Subject: CPHR comments – Response to Submissions for the Amended Proposal – WSU Indigenous Centre of Excellence (SSD-64916225)

Thank you for your correspondence received 24 December 2025 seeking comments from the Conservation Programs, Heritage and Regulation (CPHR) Group of the NSW Department of Climate Change, Energy, the Environment and Water on the Response to Submissions for the WSU Indigenous Centre of Excellence (SSD-64916225) at the Western Sydney University Parramatta South Campus, 171 Victoria Road, Parramatta.

CPHR flooding advice – Response to Submissions for the Amended Proposal – WSU Indigenous Centre of Excellence (SSD-64916225)

**Figure 49 Flood Level Impact – 1% AEP – Developed Condition**

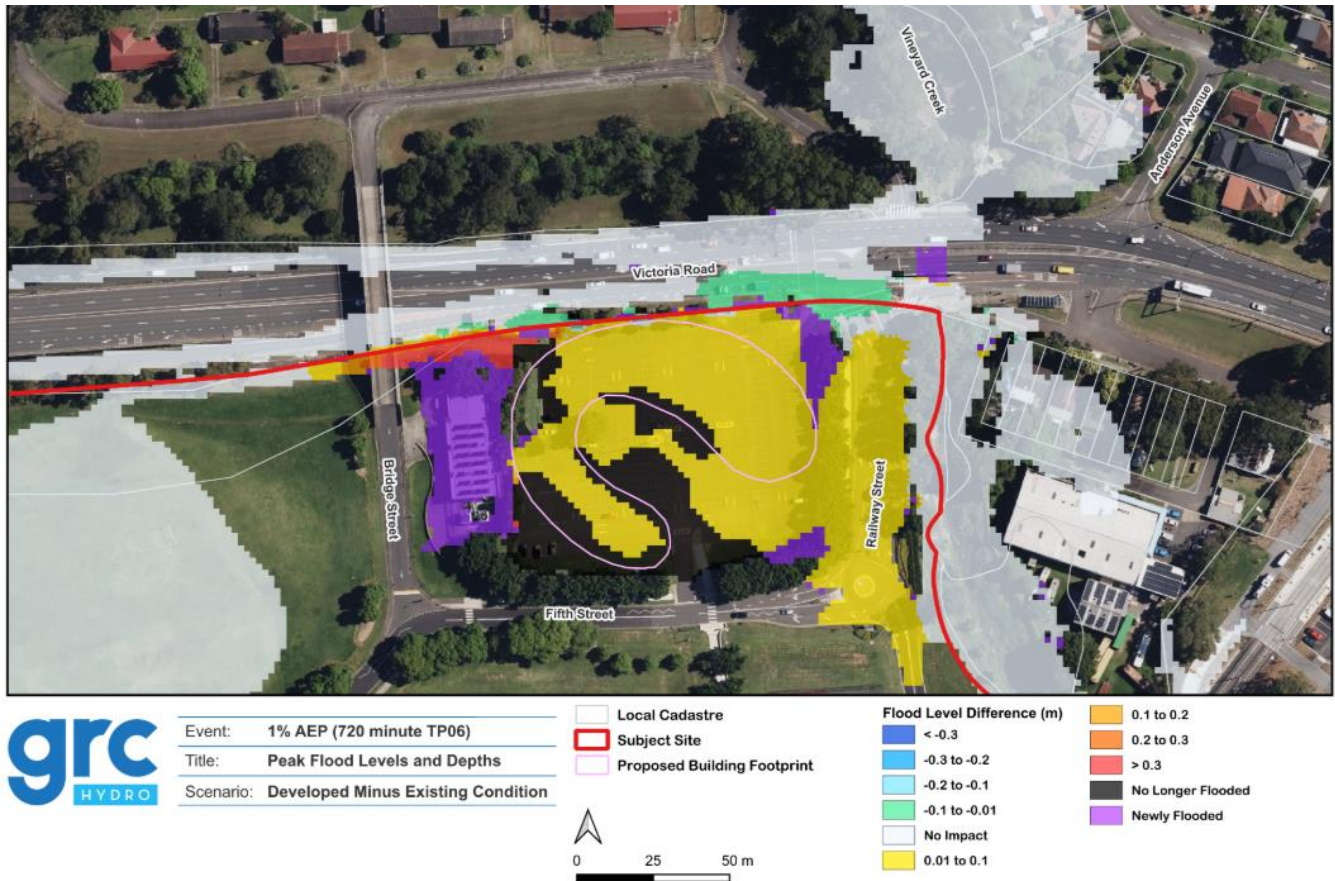
<i>Extent and Timing</i>	Pre-determination
2.	Flood impacts	Figure 41 of the FIRA shows the proposed development appears to worsen flooding conditions on the sole access road for the entire campus, Railway Street, in the event referred to as the "1% AEP" flood. Recommendation action: Detailed consideration of the impacts to Railway Street.
	<i>Extent and Timing</i>	Pre-determination
